WSU BANKSTOWN CITY CAMPUS | SSD_9831

CONSOLIDATED RESPONSE TO DPIE RFI DATED 4 NOVEMBER 2020 AND ADDITIONAL INFORMATION REQUESTED DATED 11 DECEMBER 2020.

TABLE 1 - Response to DPIE Additional Information Request dated 11 December 2020

JOB No.	DRAWN	CHECKED	DATE
1097901C	PA	-	
DRAWING No.			REVISION
C00-41			09

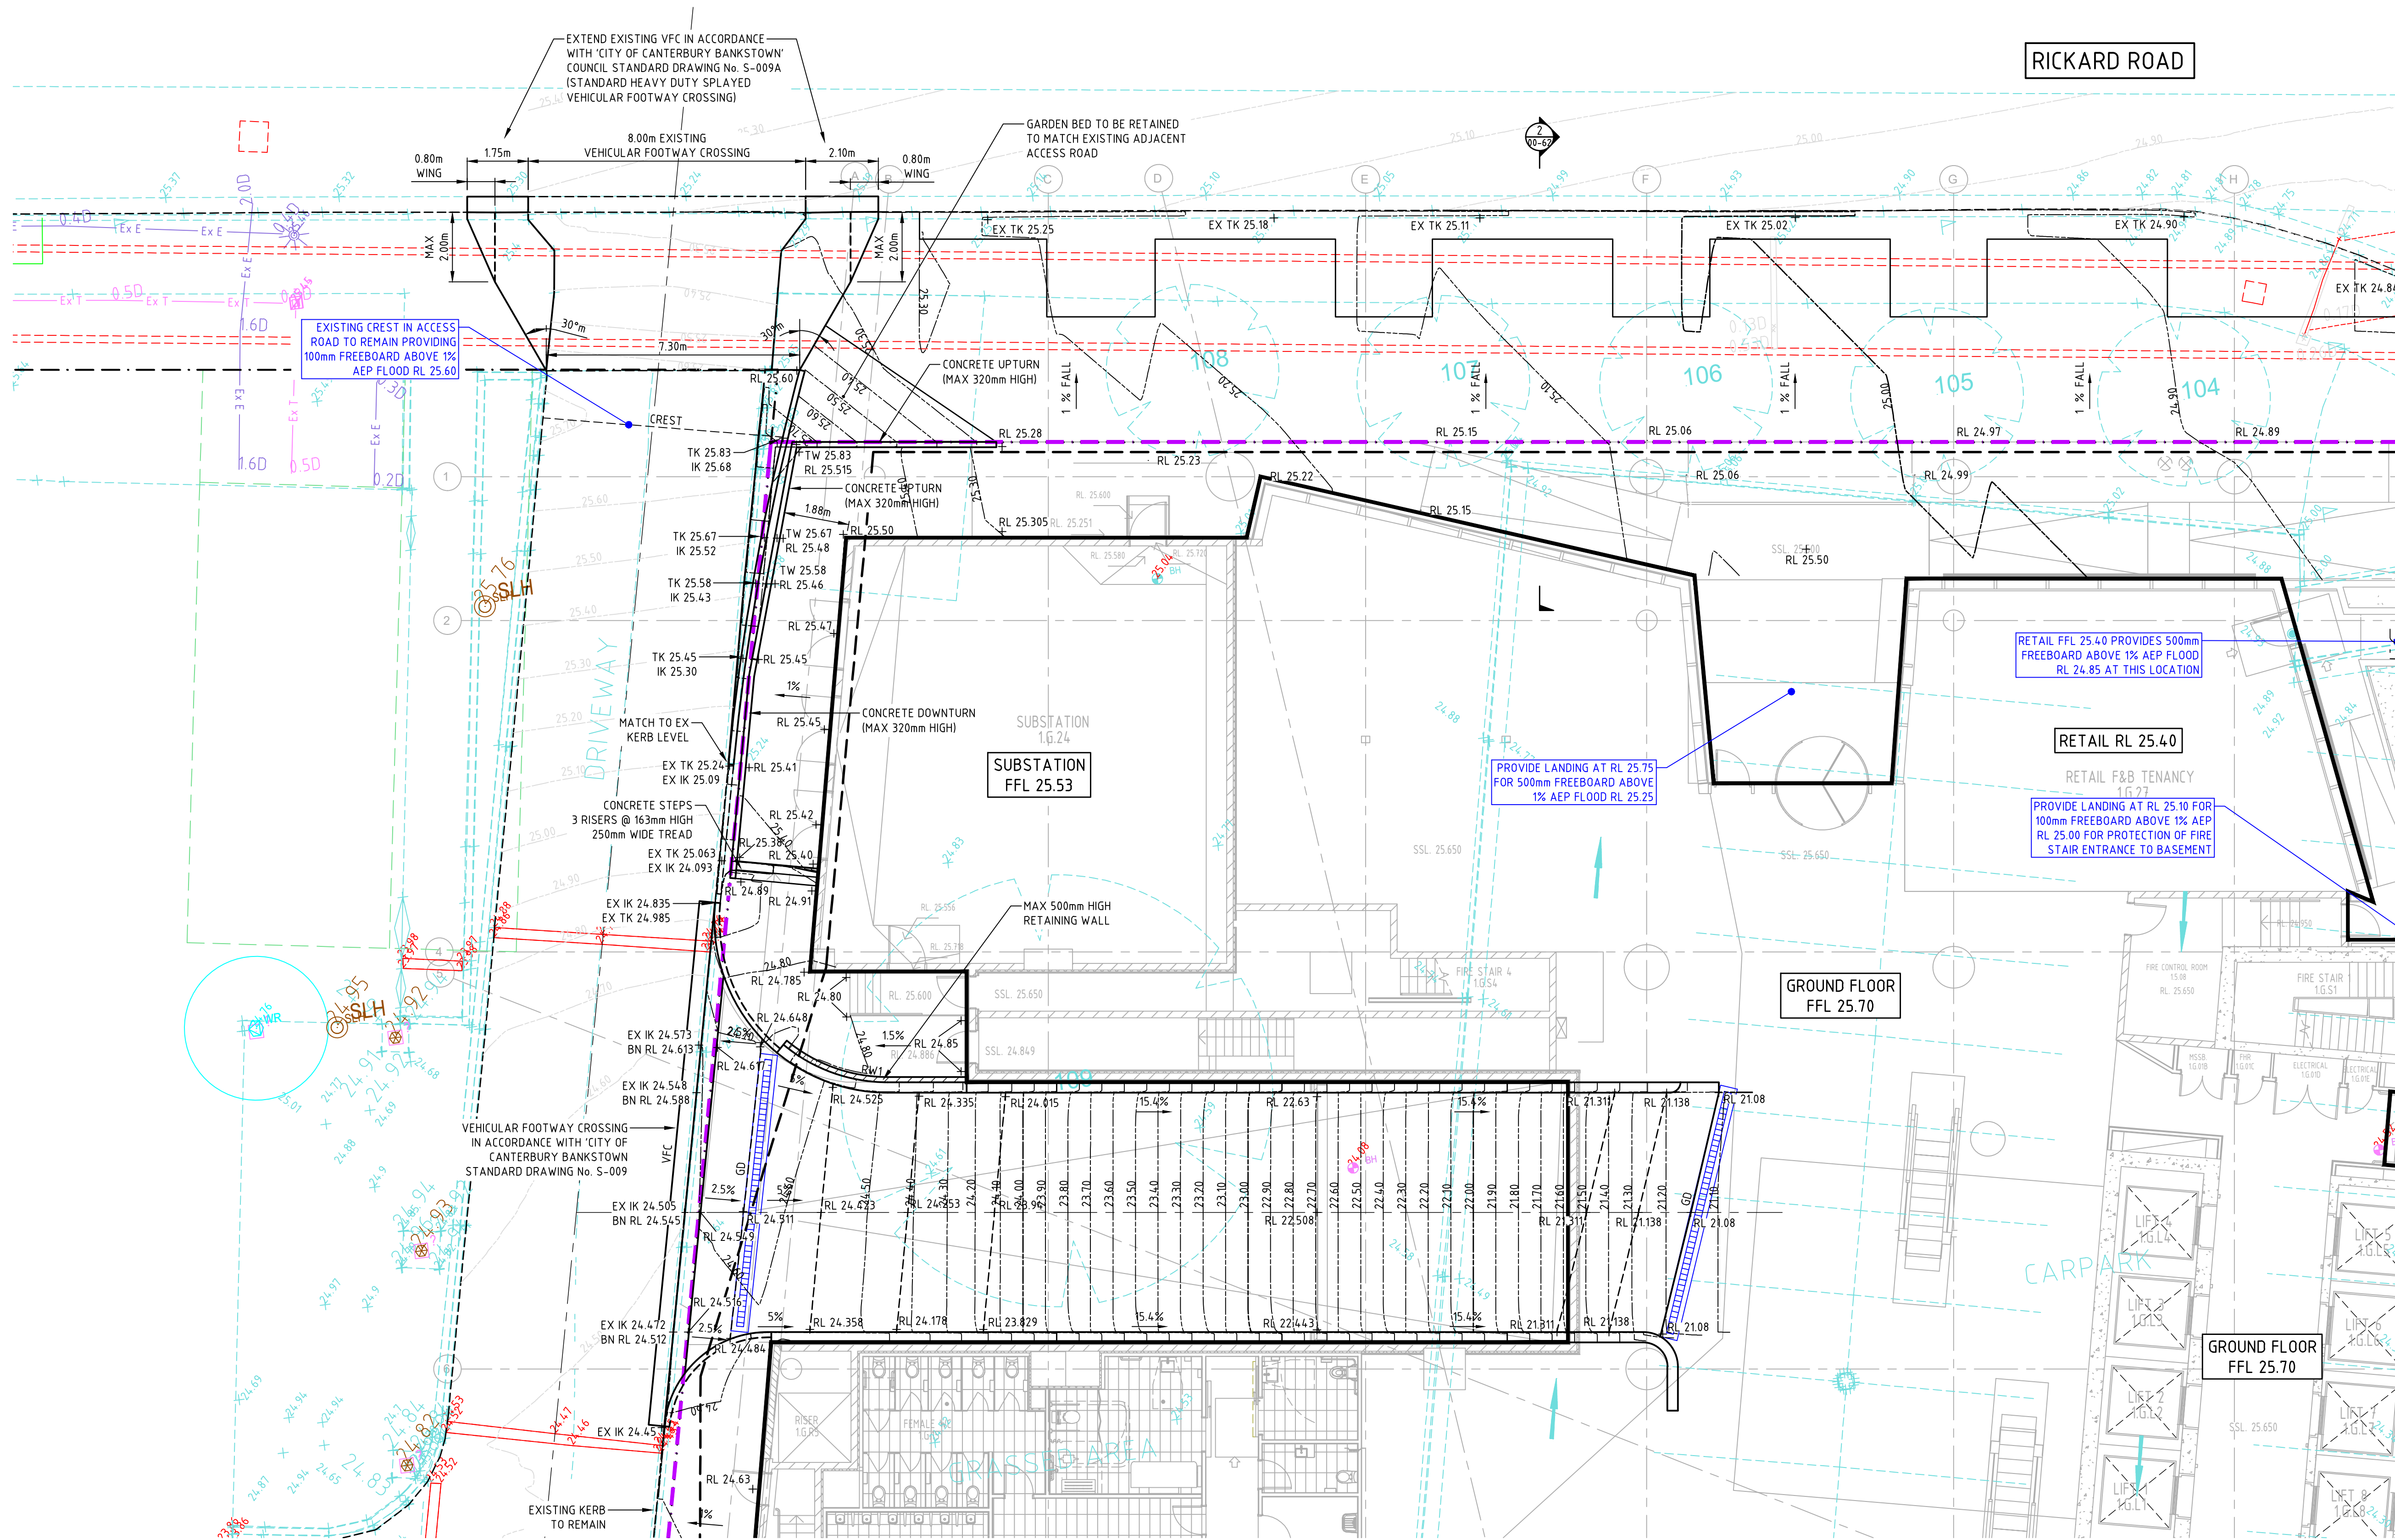
1.2	Provide a plan showing the modelled 1% AEP level, flood planning level and PMF levels adjacent to all access points to the site at the completion of the stormwater works. The same plan should show all FFLs.	Refer to Attachment B1 – Civil Drawing C00-41 prepared by Bonacci Refer to Attachment B2 – Civil Drawing C00-42 prepared by Bonacci <u>Response:</u> Both Civil drawings prepared by Bonacci include 1% AEP levels and FFL's highlighted in yellow.

C09	Alternatively, the flood assessment model and report should be revised to account for the ~12.0 m ³ /s residual flow across the “Rickard Road Median” as per Table 1 (DHI, 2020) and with Finished Floor Levels (FFL) based on this.	Refer to section 1 (Table 01) Refer to Attachment A – Council’s Option B drainage works prepared by Council on 17 November 2018.
C10	Basement driveways and fire stair entrances indicate levels to demonstrate 1% AEP and PMF flood levels (for all access points including lifts and ventilation). Commentary on the PMF flood level at the basement entry points also be provided in the amended reports.	The Bonacci assessment incorporates flood levels from Council’s Option B that are comparable to flood levels in the DHI modelling. The DHI levels were used to determine the required Finished Floor Level (FFL) at RL 25.60. The basement vehicle entrance is on the western side of the site, off the BLaCK driveway, which has an existing crest at its intersection with Rickard Road that diverts flood waters toward The Appian Way, and away from the driveway and therefore basement entrances. See drawing <i>Site and Stormwater Drainage Plan Sheet 1 C00-41 Rev 09</i> , prepared by Bonacci, at Appendix O of amended application submitted on 28 August 2020.

DRAWING No. **C00-70** REVISION **08**

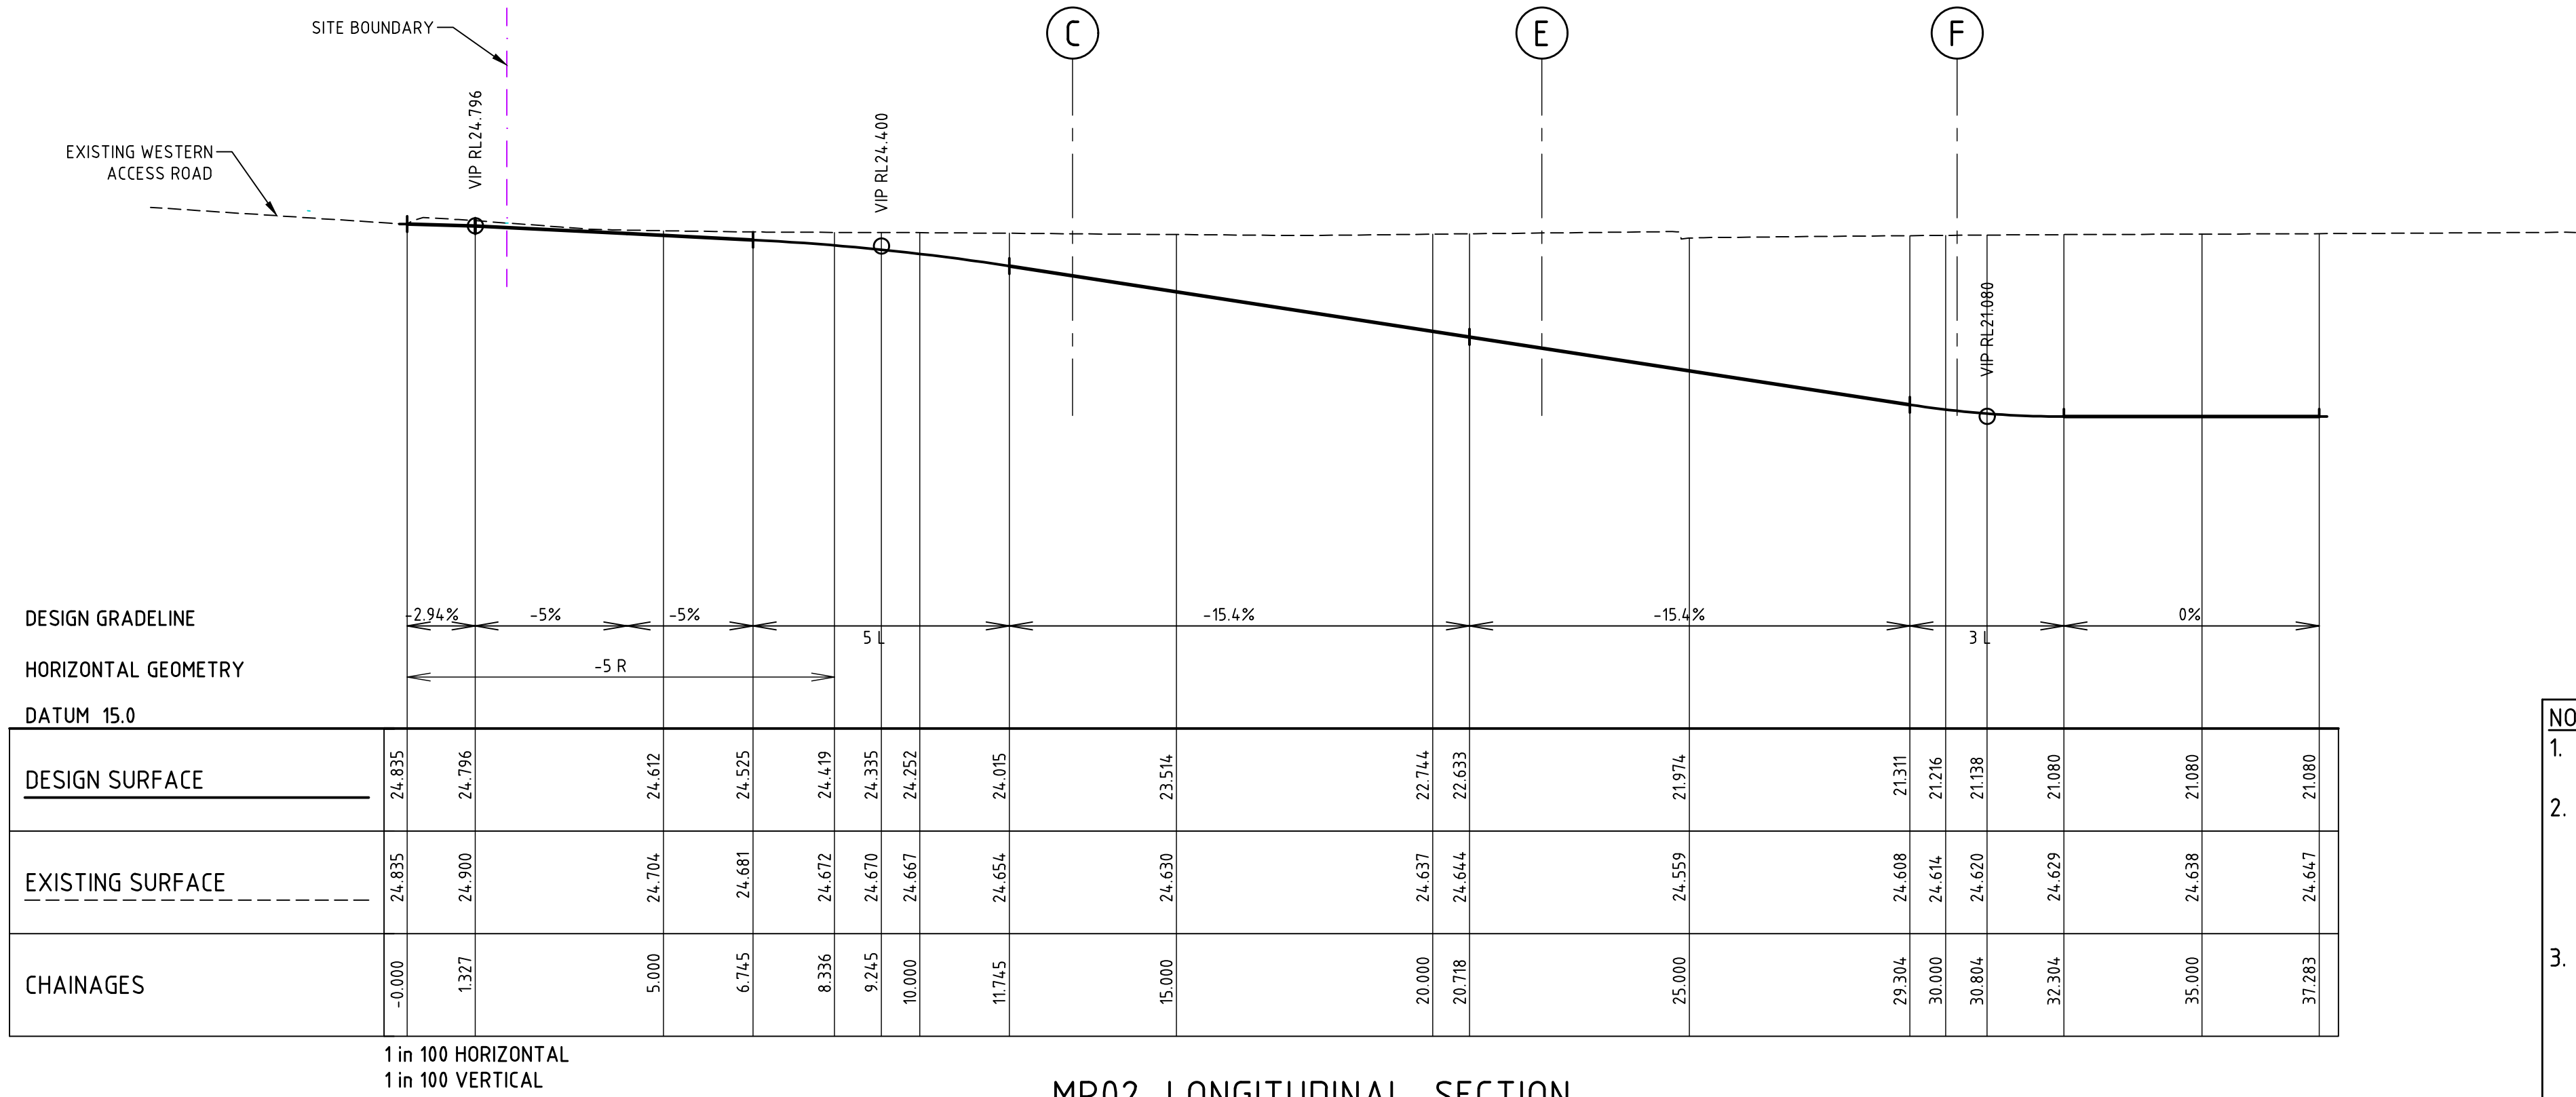
C18	Drawings are amended to show the full outline of the Sydney Water culvert.	<p>An accurate investigation survey has been carried out to clearly identify the location of the existing Sydney Water Assets Refer to Attachment M – Detailed Survey of existing underground services prepared by Crux 10 November 2020.</p> <p>The Sydney Water assets are shown on the <i>Site and Stormwater Drainage Plan Sheet 1 C00-41 Rev 09</i> and <i>Site and Stormwater Drainage Plan Sheet 2 C00-42 Rev</i> prepared by Bonacci, at Appendix O of amended application submitted on 28 August 2020.</p>
C19	Council is consulted with regards to proposed layouts of the roads and footpaths surrounding the proposed WSU site for integration into the civil design.	<p>Please see more detailed drawings <i>Site and Stormwater Drainage Plan Sheets 1, 2, 3 & 4 C00-41, 42, 43 and 44</i> prepared by Bonacci, at Appendix O of amended SSDA application submitted on 28 August 2020.</p> <p>The Civil Drawings at Appendix O of the amended SSDA proposal detail the proposed treatment of external ground level, and the adjoining public domain, including pavements, typical sections, roads and kerb set outs, pavement cross sections and the interface area. Please refer to the following drawings prepared by Bonacci:</p> <ul style="list-style-type: none"> • C00-60 Site works and Stormwater Details Sheet 1 Rev 08 • C00-61 Site works and Stormwater Details Sheet 2 Rev 08 • C00-62 Typical Site Sections Rev 04 • C00-65 Council standard layback Rev 04 • C00-70 Overall Pavement Plan Rev 08 • C00-61 Site works and Stormwater Details Sheet 2 Rev 08 • C00-70 Overall Pavement Plan Rev 08 • C00-75 Pavement Details Rev 02
